Application for a Non-Material Amendment Following a Grant of Planning Permission

Entrance Porch at Front of House and Glazed Roof over Patio at Rear of House

22/0336/HH

Change of materials for the structure/finish of the proposed Porch to natural timber - 'Fresh Sawn Euro Oak' - as detailed on Dwg No 22.14.03

dwg no:- 22.14.03 scale:- 1:100 (A4) date:- Mar 2024

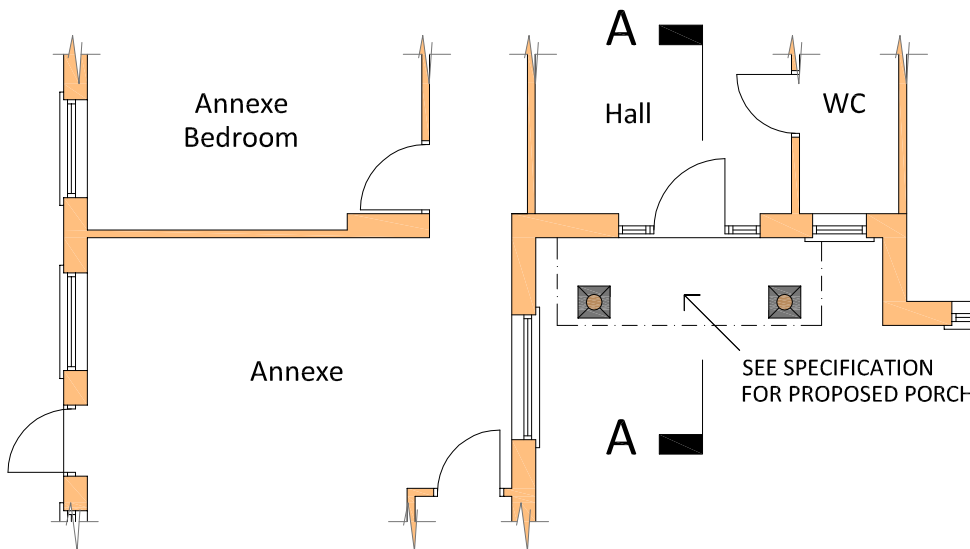
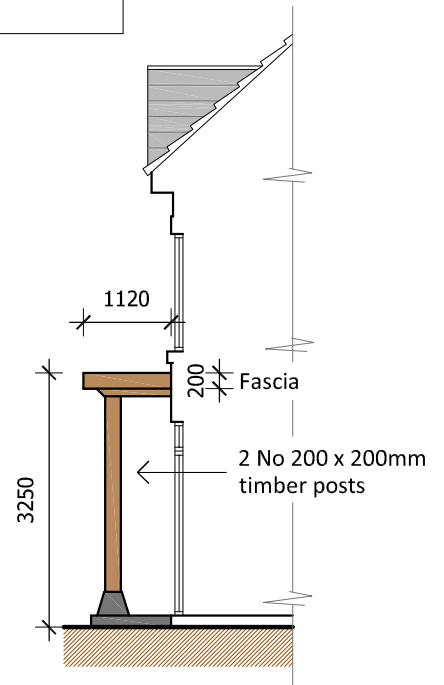
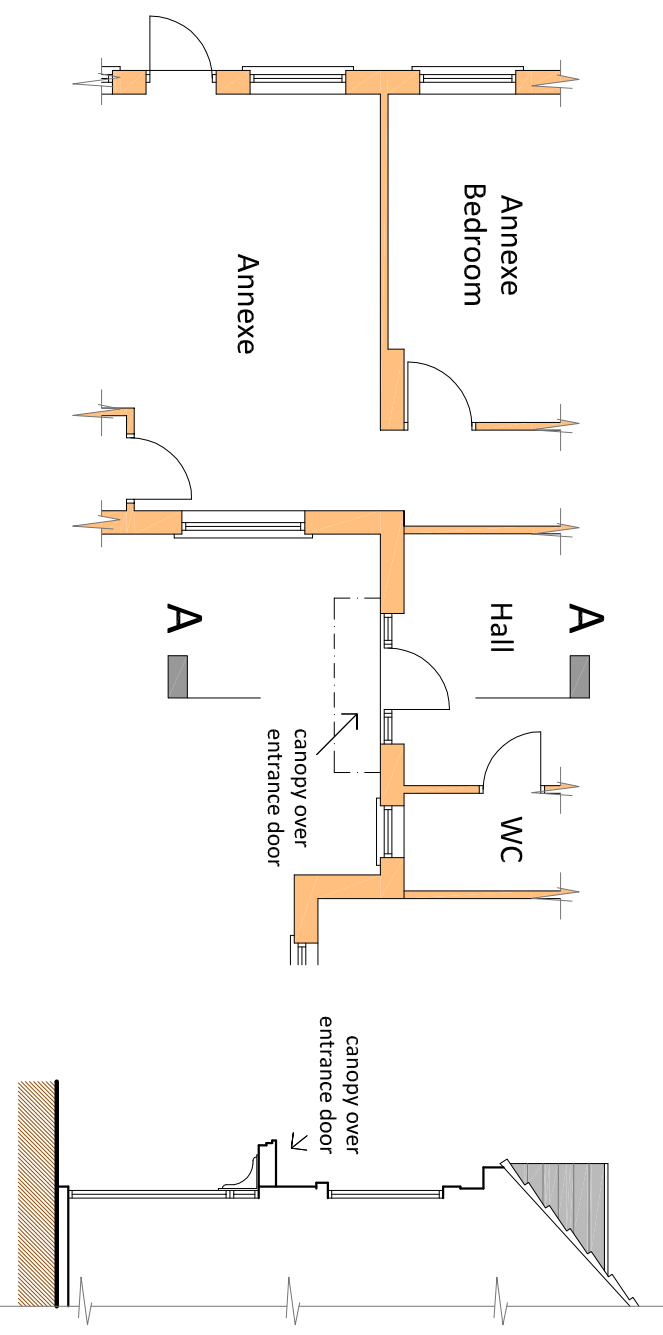
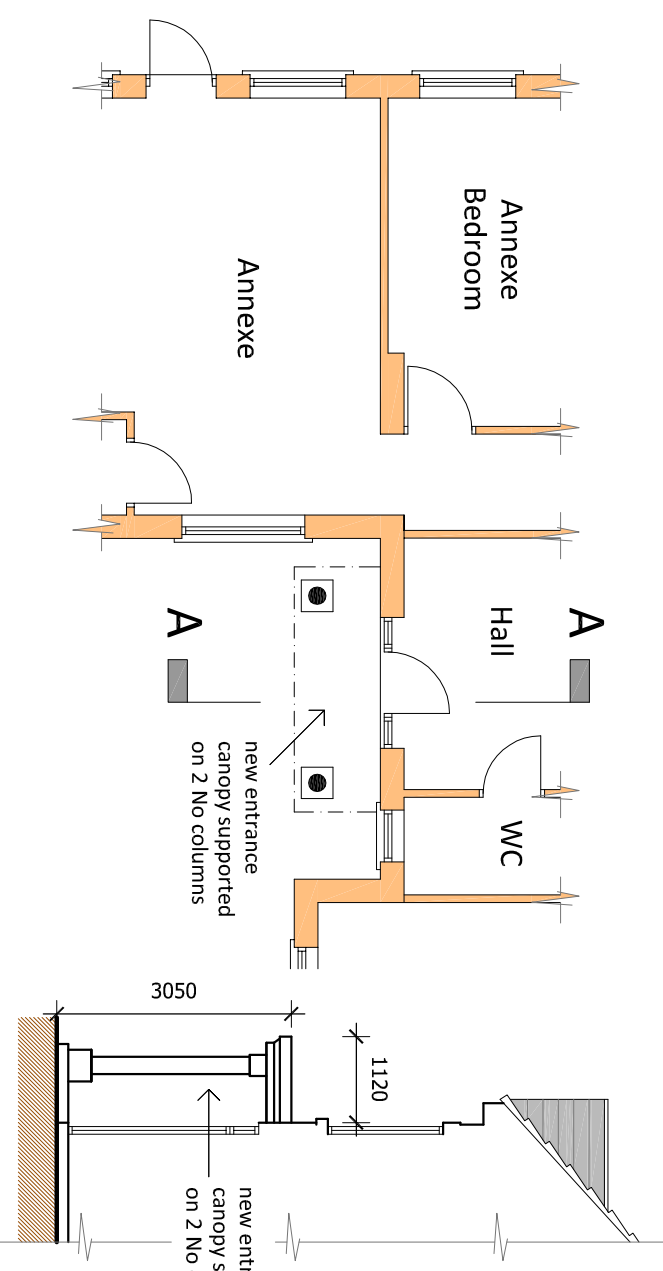
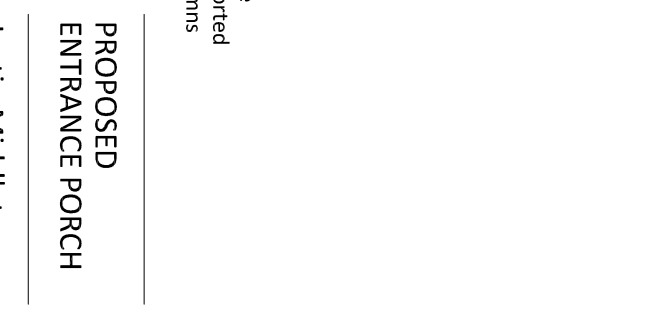
It is felt that a natural timber 'Fresh Sawn Euro Oak' structure/finish more closely reflects the rural nature of the location.
